From: Simon Davis
Sent: 11 February 2019 17:22
To: 'Jonathan Pritchard'
Subject: BR/311/18/PL Chichester University

Current Scheme (6655) - December 20th 1044hrs

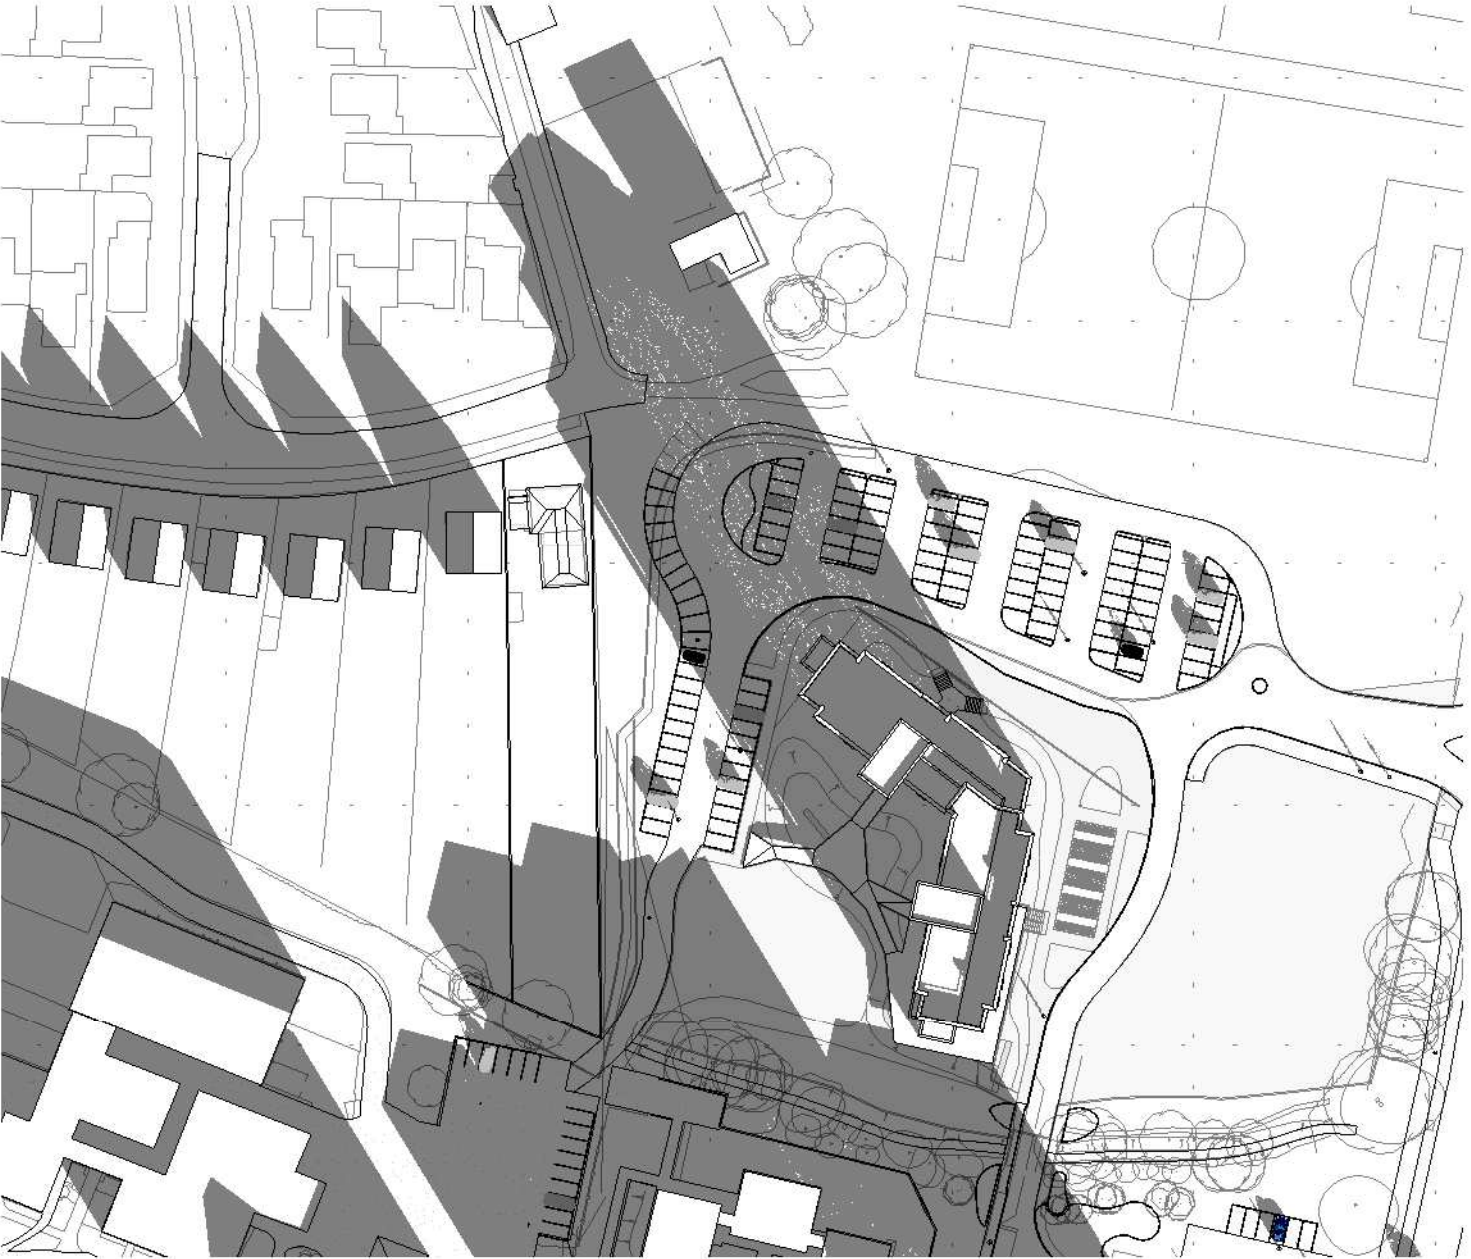
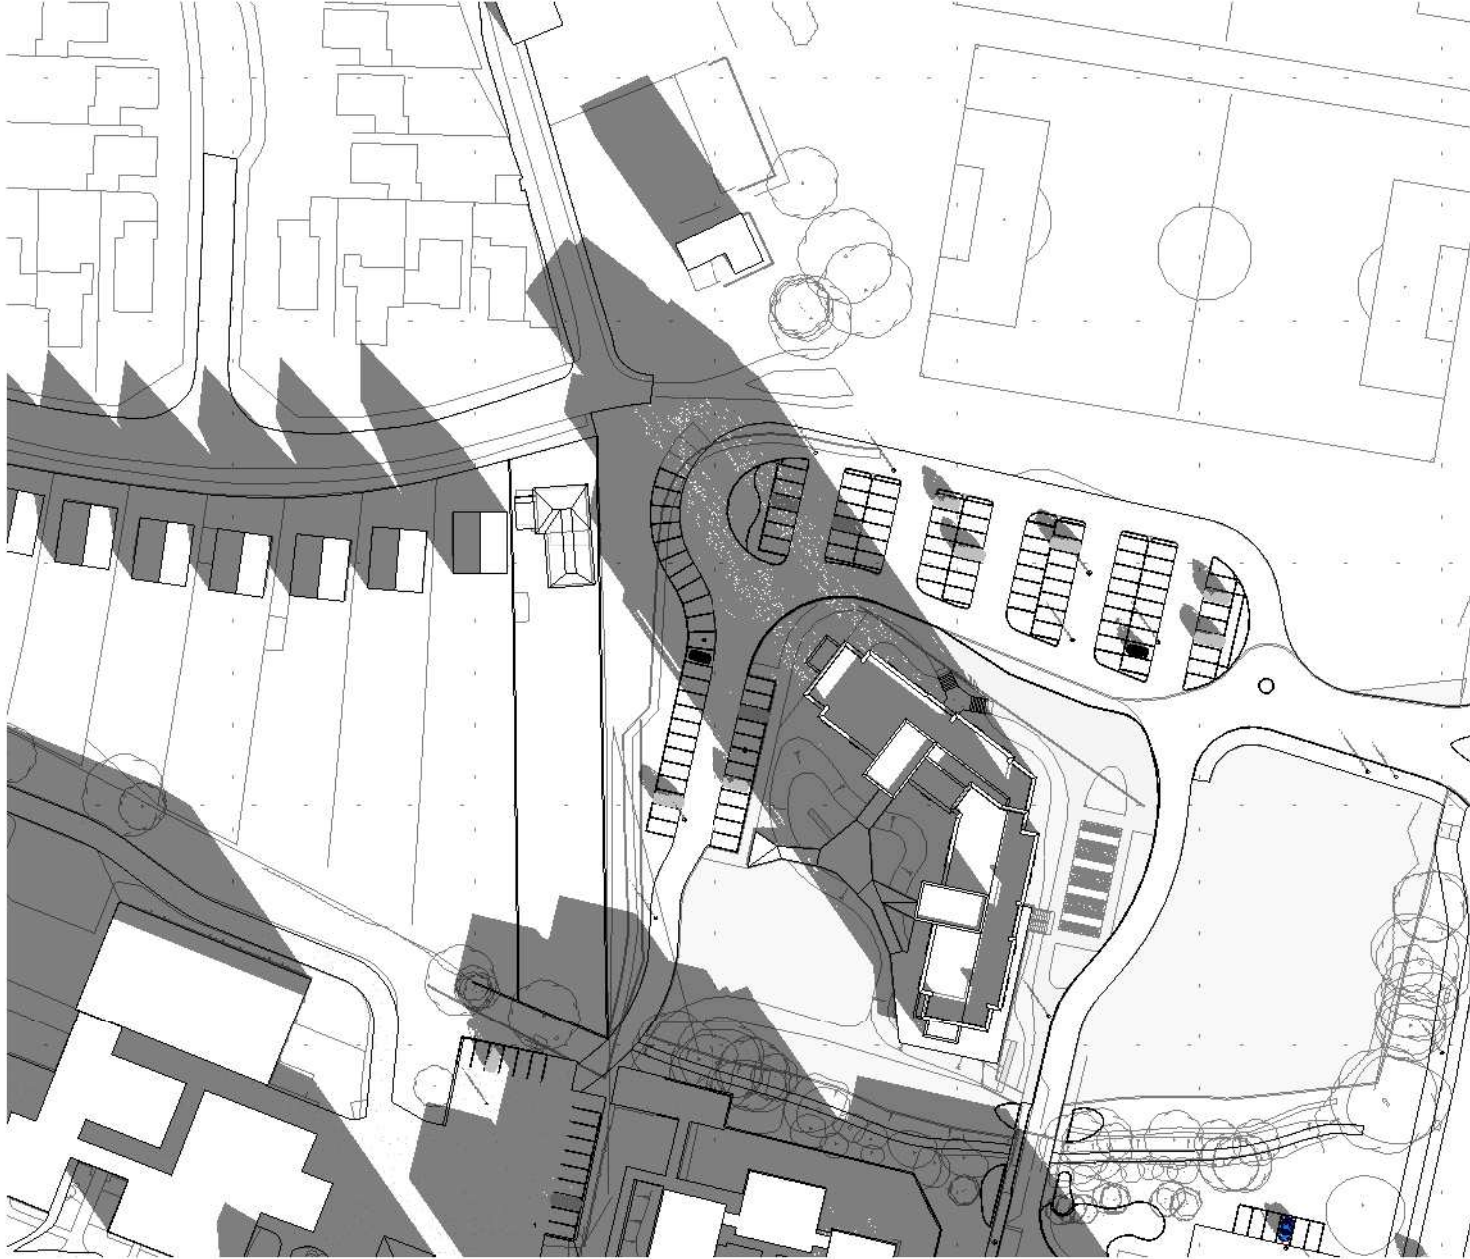
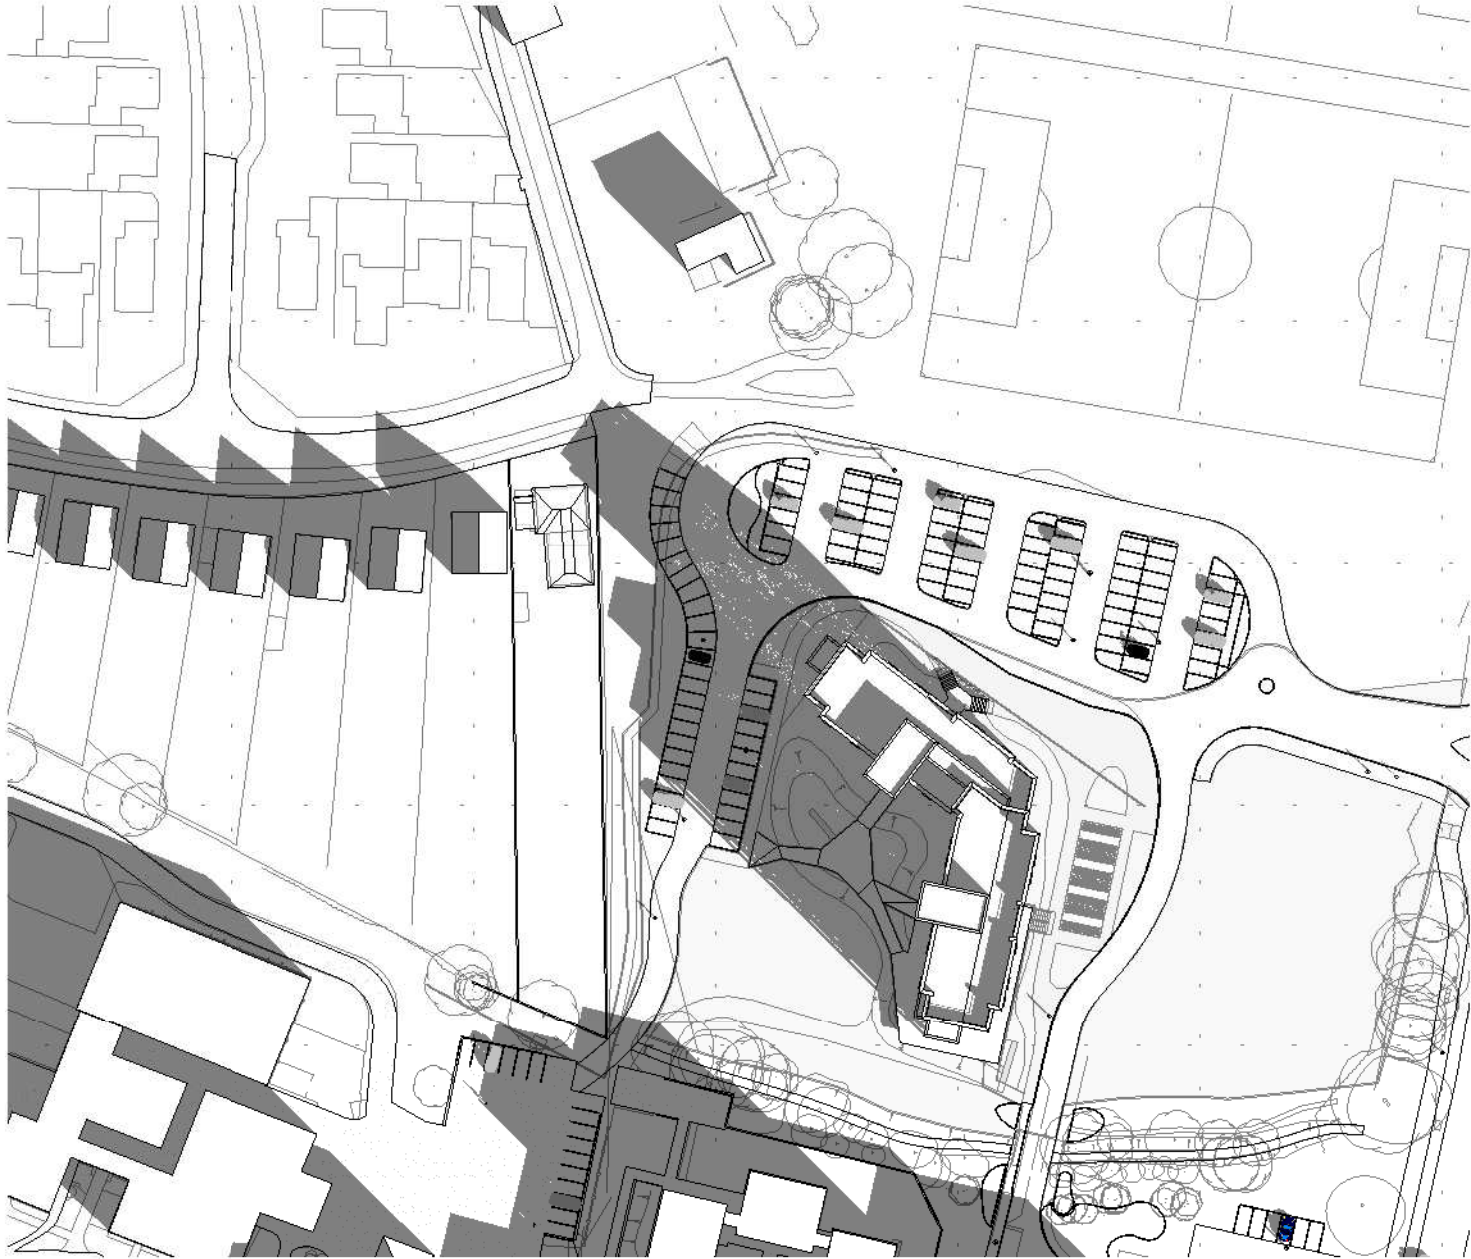
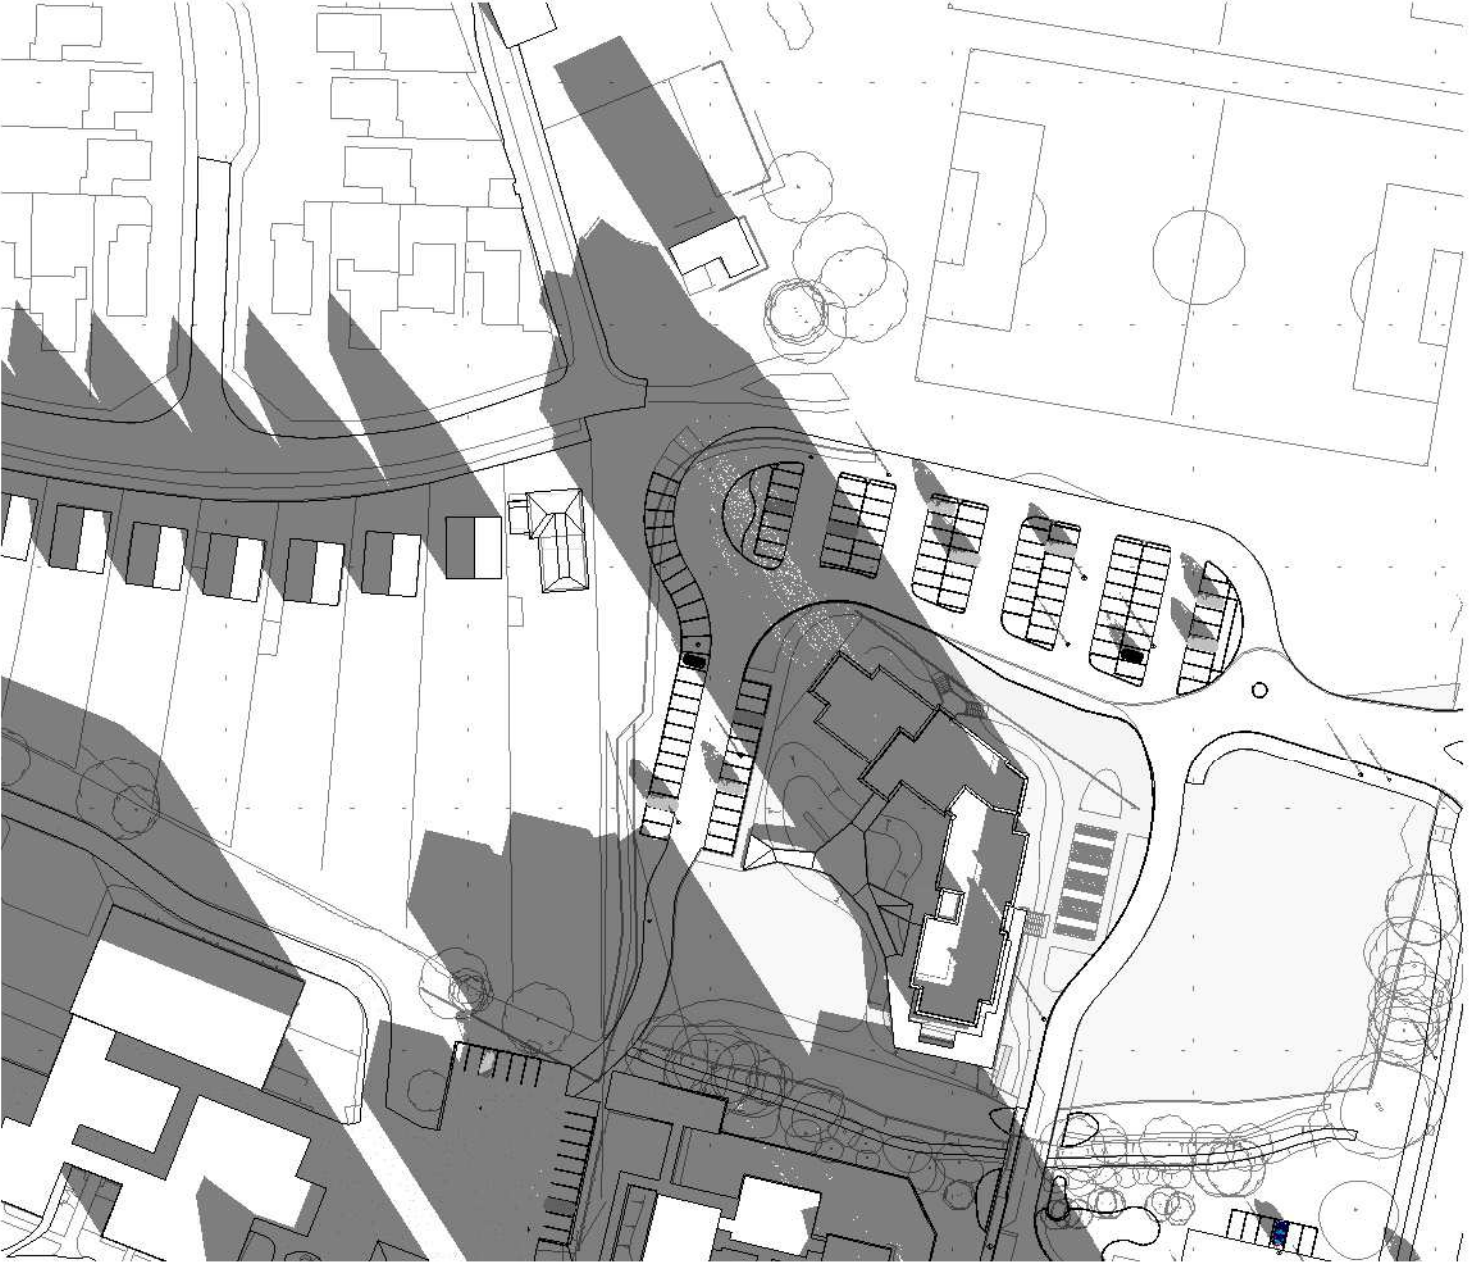
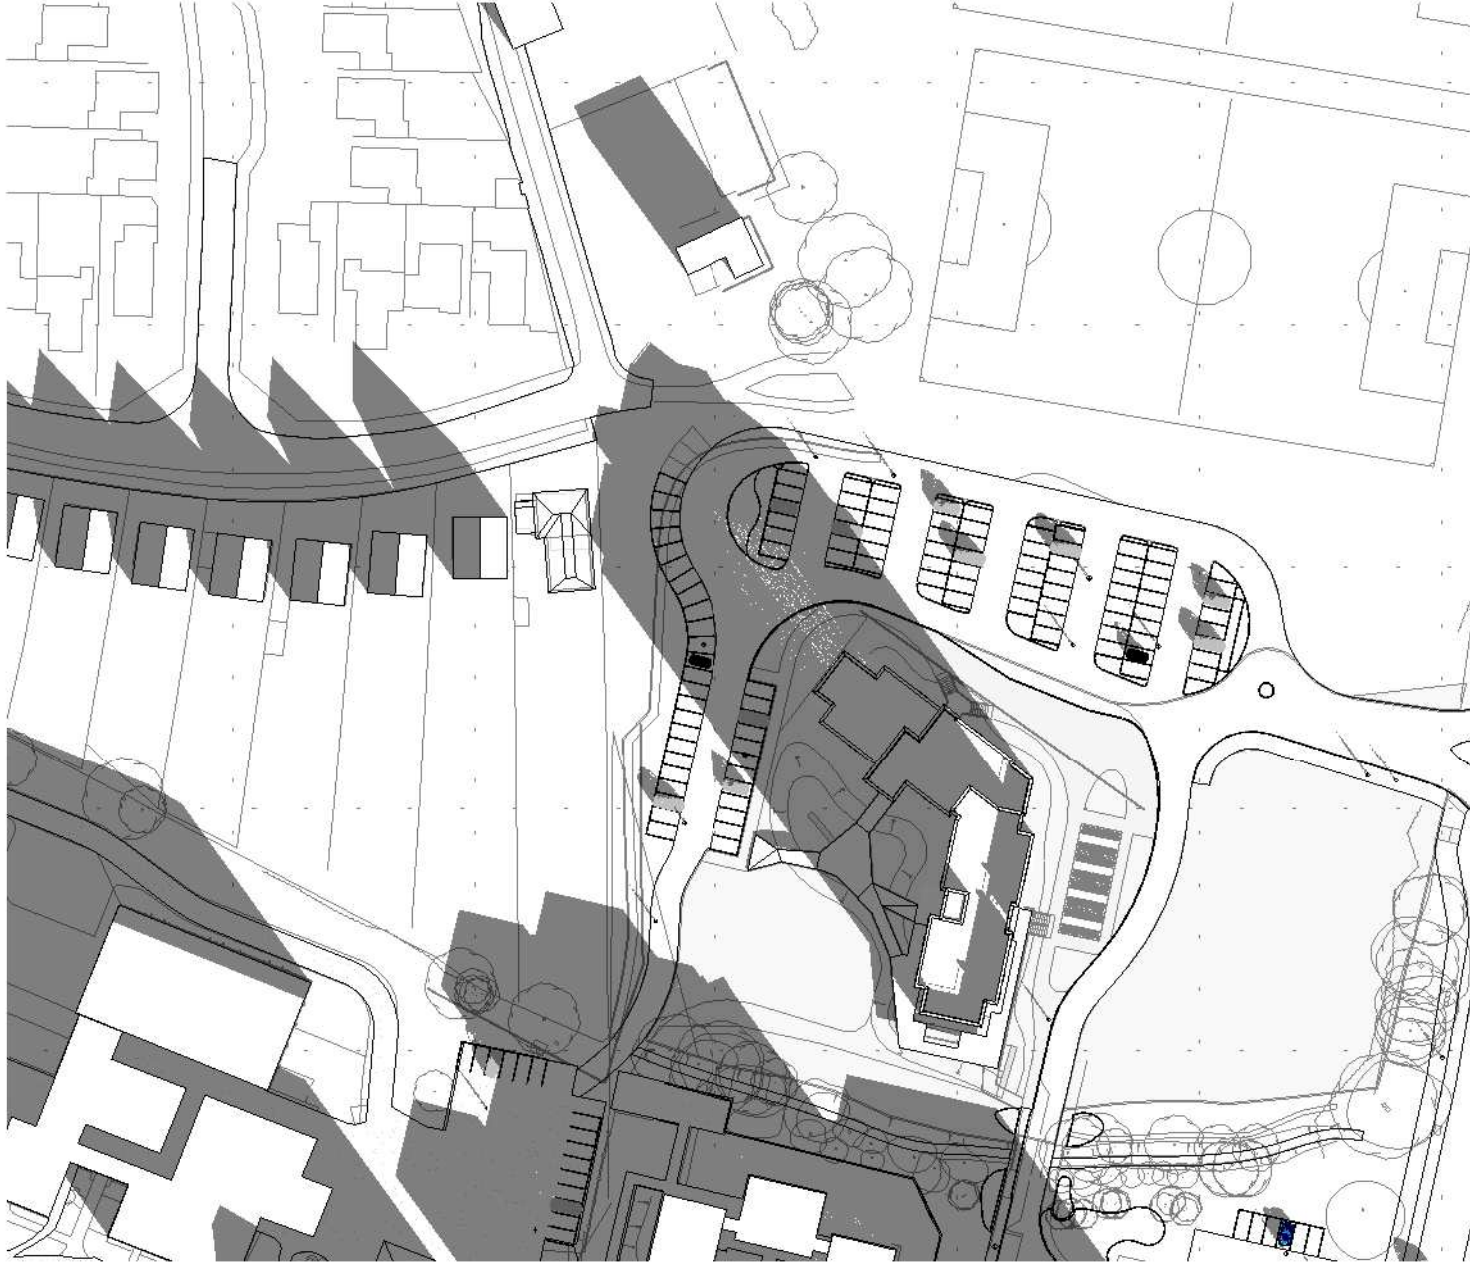
It was discussed that on the previous application, the part of the building facing the Hook Lane dwellings was reduced from 6 storeys to 3/4 and this resulted in a reduction in bed spaces from 171 to 136. I read in the D&A that you have reverted back to the original height (albeit 5 not 6 storeys at this end) because you have re-assessed the shading analysis and found the impact it to be acceptable. However, having read the original report, I note that the request to lower the building was partly on grounds of shading and partly on grounds of an overbearing impact. I consider that the overbearing impact remains and therefore, I consider that this end of the building should be lowered. However, it may not be necessary to revert back to the 6643 approval – a 6653 scheme could be acceptable.
